20 October 2016 OUR REF: 603049-01000

Re: Salvation Army Barrhaven Church – 102 Bill Leathem Drive TB Addendum #1

This Addendum has been prepared to address the comments received from the City of Ottawa with corresponding responses from Parsons. The most recent Site Plan is attached.

DRAWING TITLE
 PHASE 2: SITE PLAN

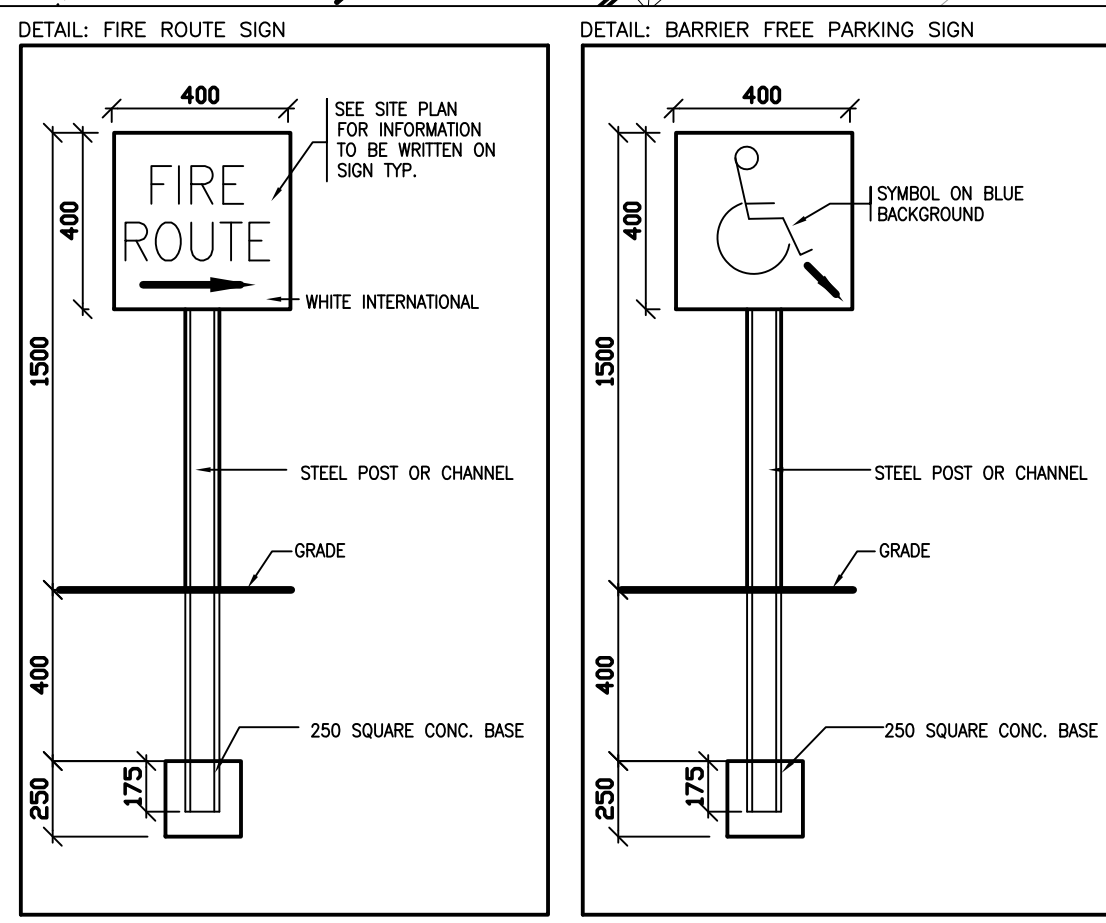
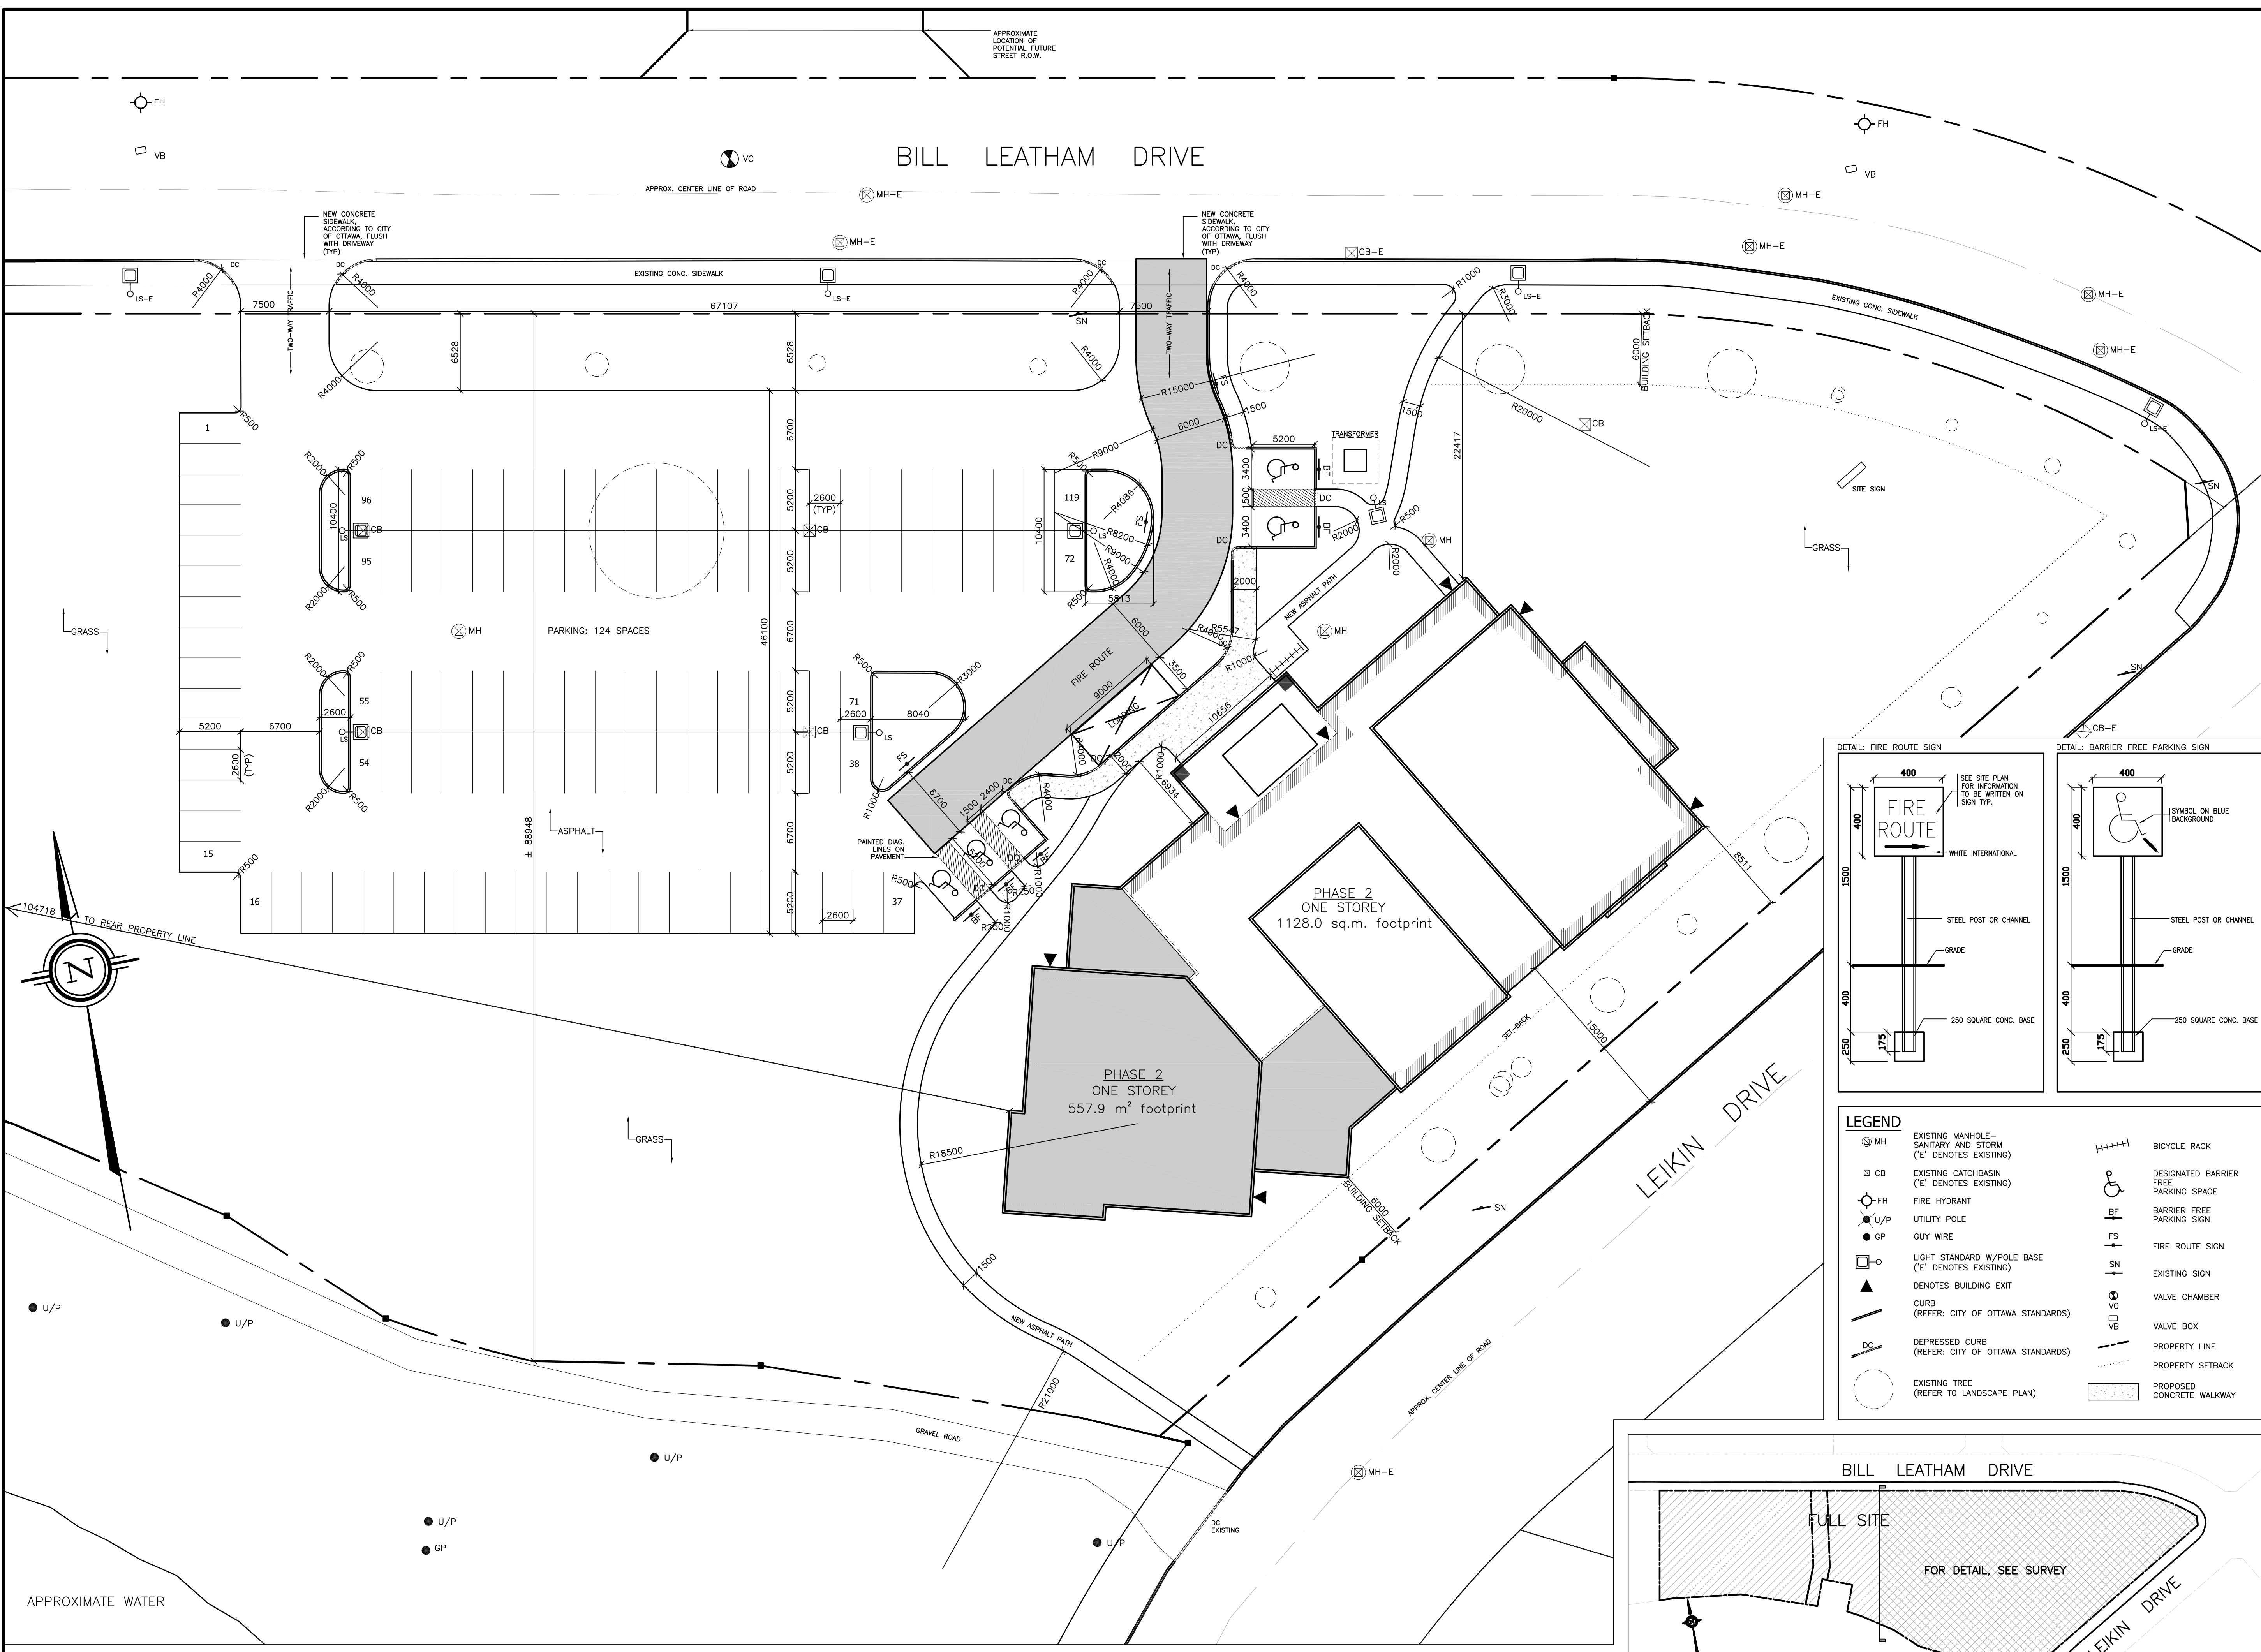
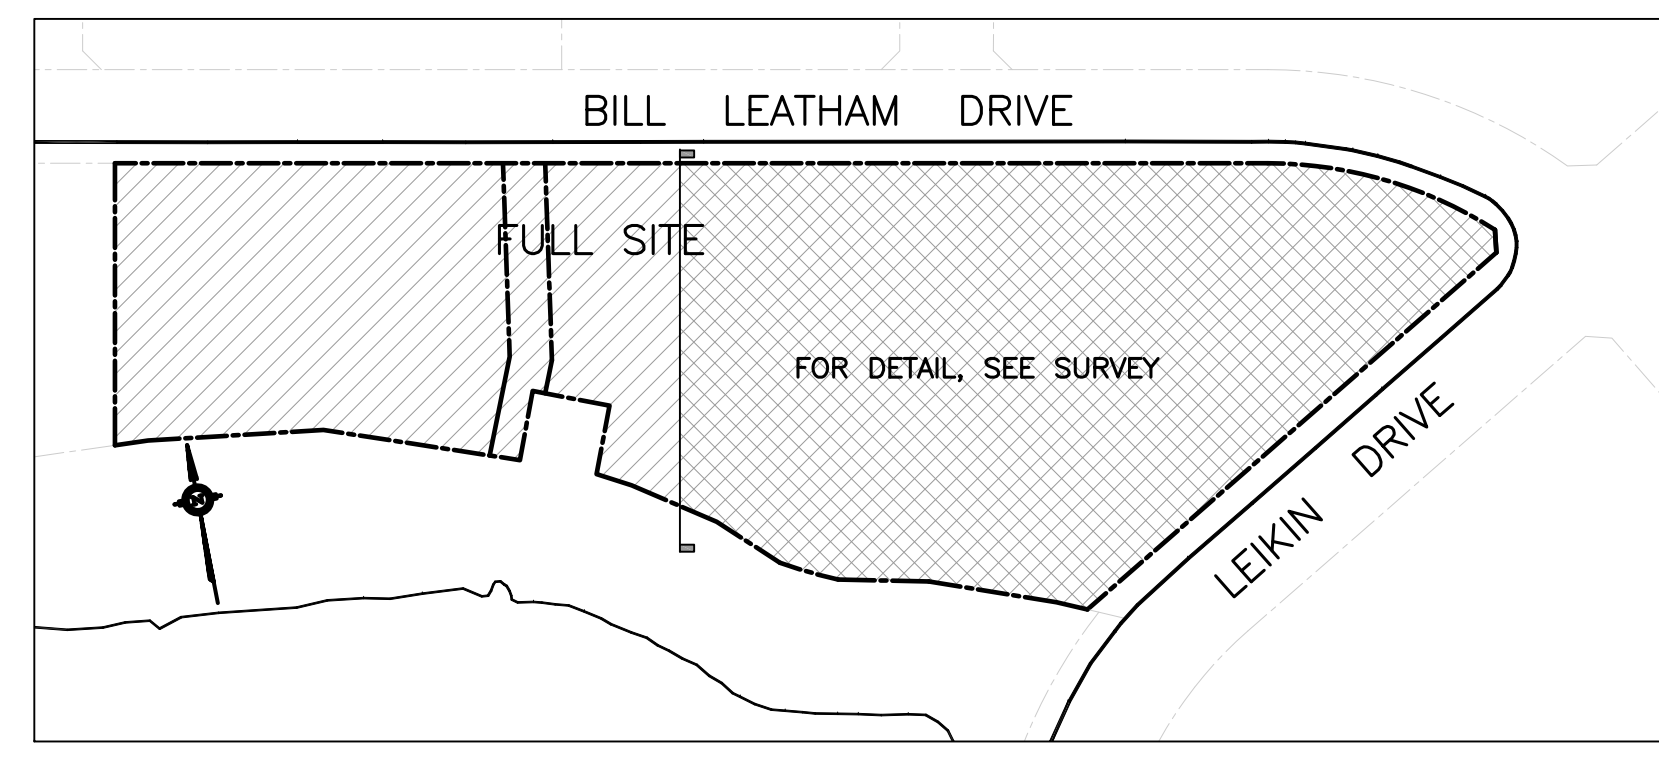
Comment B: The Transportation Brief should show total volumes at build out. It would be beneficial to align the east proposed accesses with the north side future road. This could potentially avoid any future conflict when this area is more mature.

With respect to the future private road connection north of Bill Leathem Drive, the exact location, development and timing are unknown and subject to change given it is not a public road. Bill Leathem Drive is a collector road and the traffic impacts of the proposed church are minor during the peak hours (see above), as such, the site accesses have been designed to suit the needs of this private institution.

1 PARTIAL SITE PLAN
 A100 SCALE: 1:250

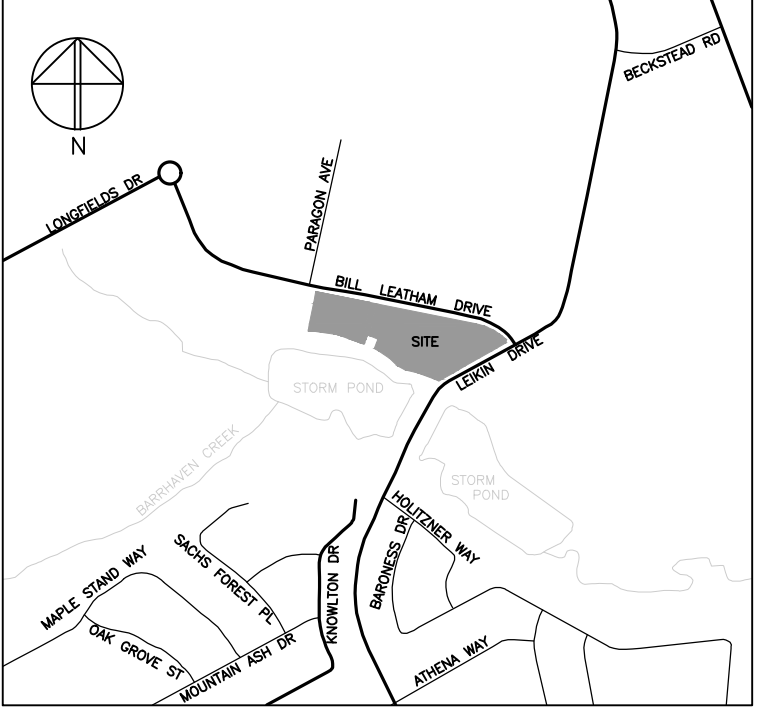
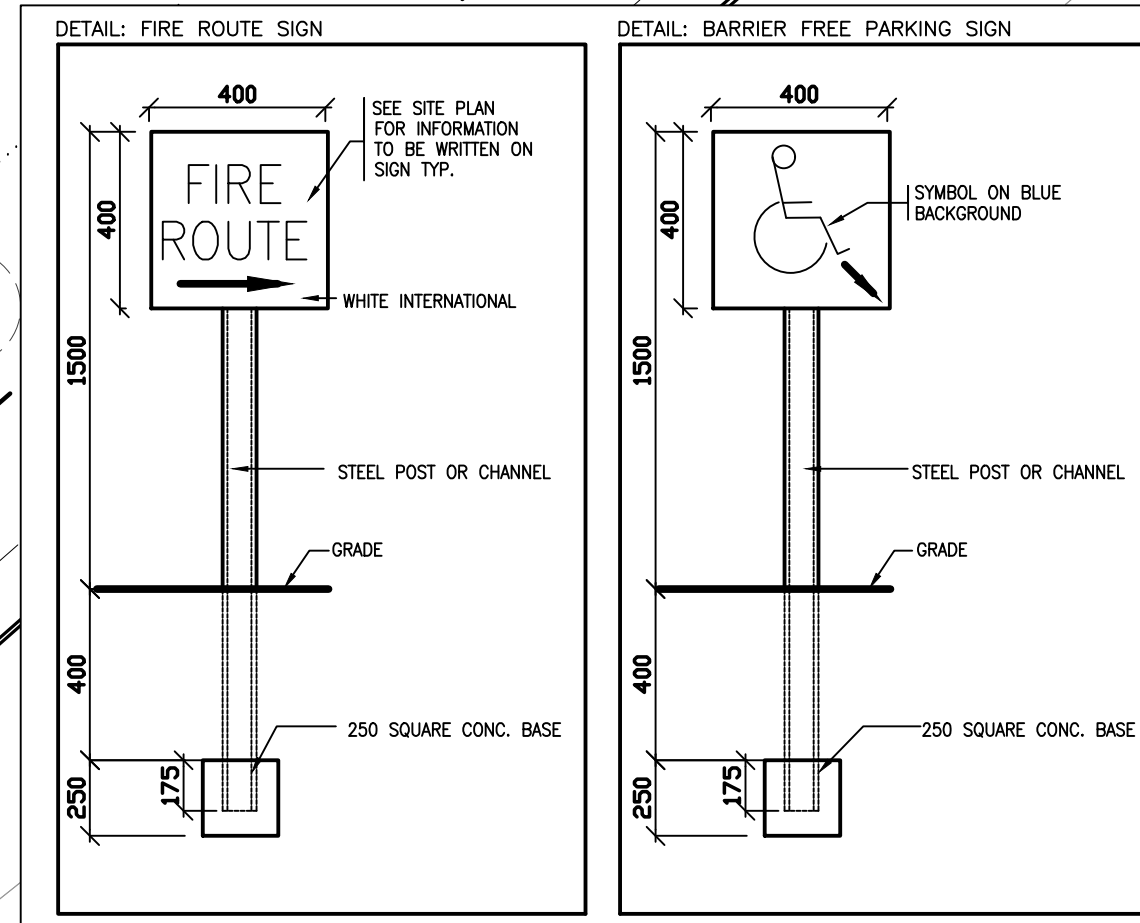
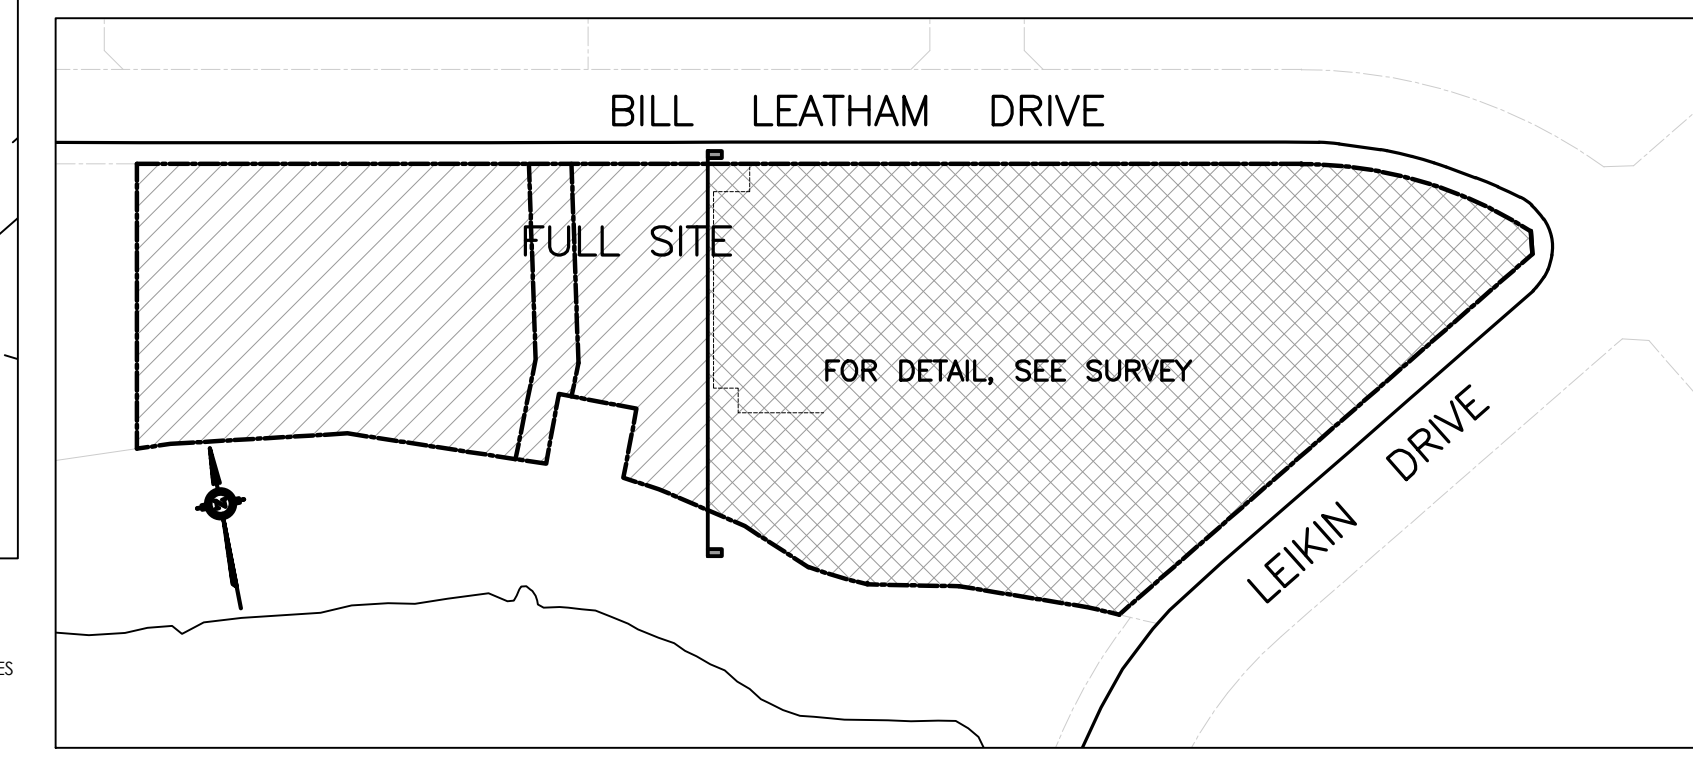
Comment E: The bus stop #3753 is to be maintained. The applicant shall construct a new concrete shelter pad at no cost to the City, as per City specifications SC-11 attached. Consideration should also be given to extending the site along Leikin Drive in order to improve connections and provide pedestrian friendly amenities in the area. The site plan shall be revised to show how these transit amenities will accommodated.

Response E: The bus stop can be maintained given the proposed Site Plan. According to the revised Site Plan, a concrete sidewalk is planned along Leikin Drive as part of Phase 2 of the development.
